Item No. **Report of the Interim Director of Planning, Regeneration & Public Realm**

Address 1 DALE CLOSE PINNER

Development: Demolition of existing garage. Erection of a single storey front, side and rear extension

LBH Ref Nos: **3601/APP/2022/2242**

Our proposed front extension

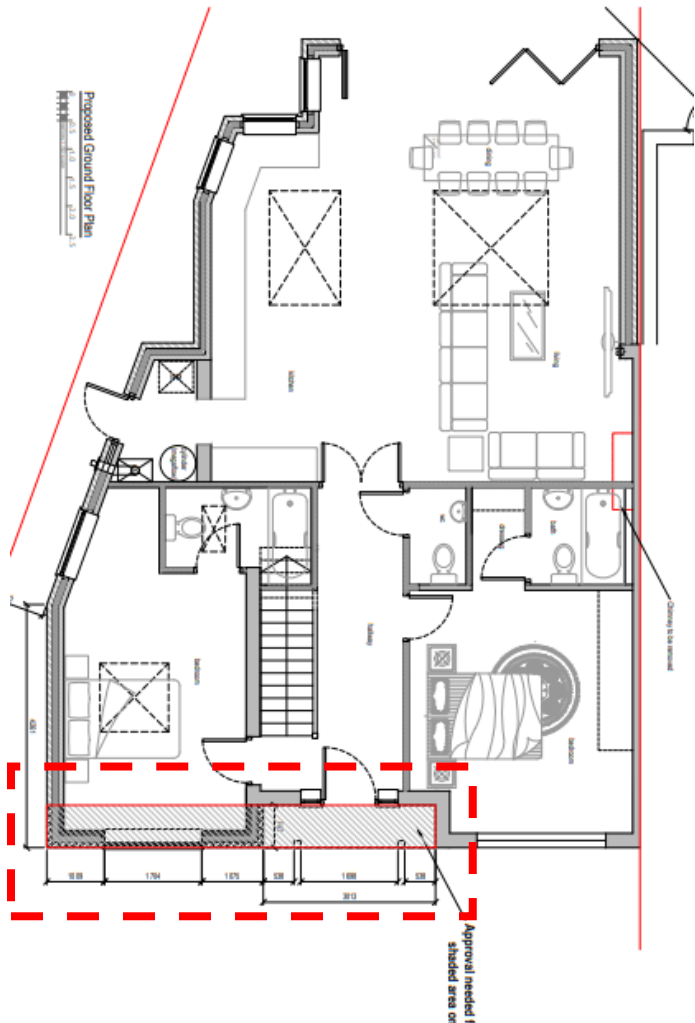
However, the addition of the front extension which extends across the approved side extension and front of the property is unacceptable. It is noted that the detached garage does not set a precedent for depth. As per Policy DMHD 1 of the Hillingdon Local Plan: Part Two - Development Management Policies (2020) alterations and extensions to the front of a house must be minor and not alter the overall appearance of the house or dominate the character of the street. Furthermore, front extensions extending across the entire frontage will be refused. The current approved plans allow for the recently approved side extension to appear subordinate, however the proposed front extension fails to comply with this policy and proportionally results in extensions that are not subordinate. This would harmfully fail to respect the proportions and appearance of the original dwelling, visual amenity of the street scene and character of the area.

The proposed front extension by reason of size, scale, bulk, projection and design would result in an incongruous and visually intrusive form of development that could not be considered to constitute subordinate addition to the existing dwellinghouse and in combination with the proposed extensions, failing to respect the architectural composition of the existing dwellinghouse resulting in a detrimental impact on the character and appearance of Dale Close. The proposal would therefore be contrary to Policy BE1 of the Hillingdon Local Plan: Part One - Strategic Policies (2012), Policies DMHB 11, DMHB 12 and DMHD 1 of the Hillingdon Local Plan: Part Two- Development Management Policies (2020) and Chapter 12 of the National Planning Policy Framework (2021).

Proposed

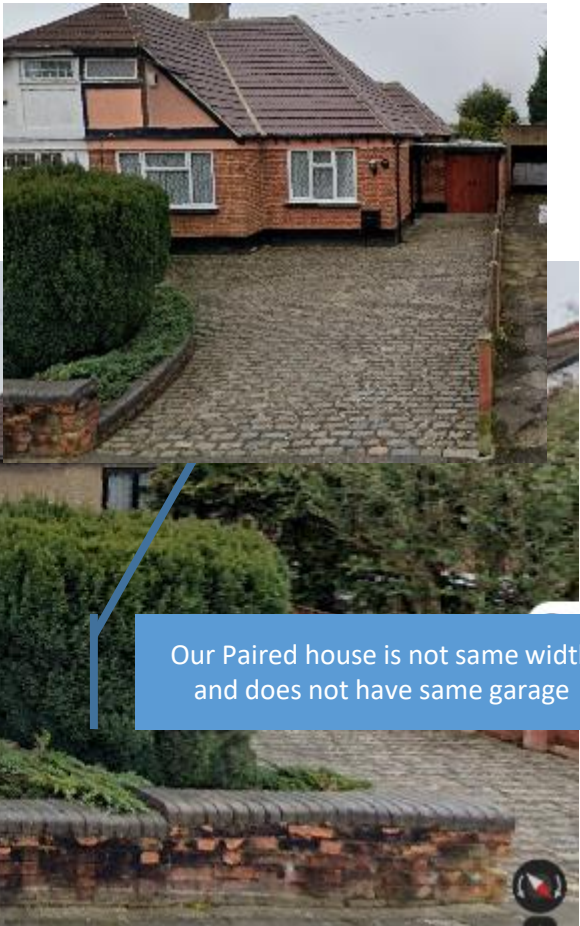
It is also important to note that the roof extension shown on the plans has been approved under a CLD application (ref: 3601/APP/2021/4475), but has not been built out. Given that it would join the proposed front and side extension it would no longer be permitted development and would require planning permission. Therefore, while the applicant has not proposed this as part of the application it should be considered given that it could not be lawfully built out in combination with the development proposed on this application (but is shown on the plans). Never hipped-to-gable roof extensions or large rear dormers are characteristic of the adjacent bungalows in the area and are contrary to local plan policy. However the scale of the rear roof extension is excessive and contrary to planning policy. The cumulative impact of the proposed roof extensions and the front/side/rear extensions by reason of size, scale, bulk, projection and design would result in an incongruous and visually intrusive form of development that could not be considered to constitute subordinate addition to the existing dwellinghouse, failing to respect the architectural composition of the existing dwellinghouse resulting in a detrimental impact on the character and appearance of Dale Close.

The cumulative impact of the proposed roof extensions and the front/side/rear extensions by reason of size, scale, bulk, projection and design would result in an incongruous and visually intrusive form of development that could not be considered to constitute subordinate addition to the existing dwellinghouse, failing to respect the architectural composition of the existing dwellinghouse resulting in a detrimental impact on the character and appearance of Dale Close. The proposal would therefore be contrary to Policy BE1 of the Hillingdon Local Plan: Part One - Strategic Policies (2012), Policies DMHB 11, DMHB 12 and DMHD 1 of the Hillingdon Local Plan: Part Two- Development Management Policies (2020) and Chapter 12 of the National Planning Policy Framework (2021).
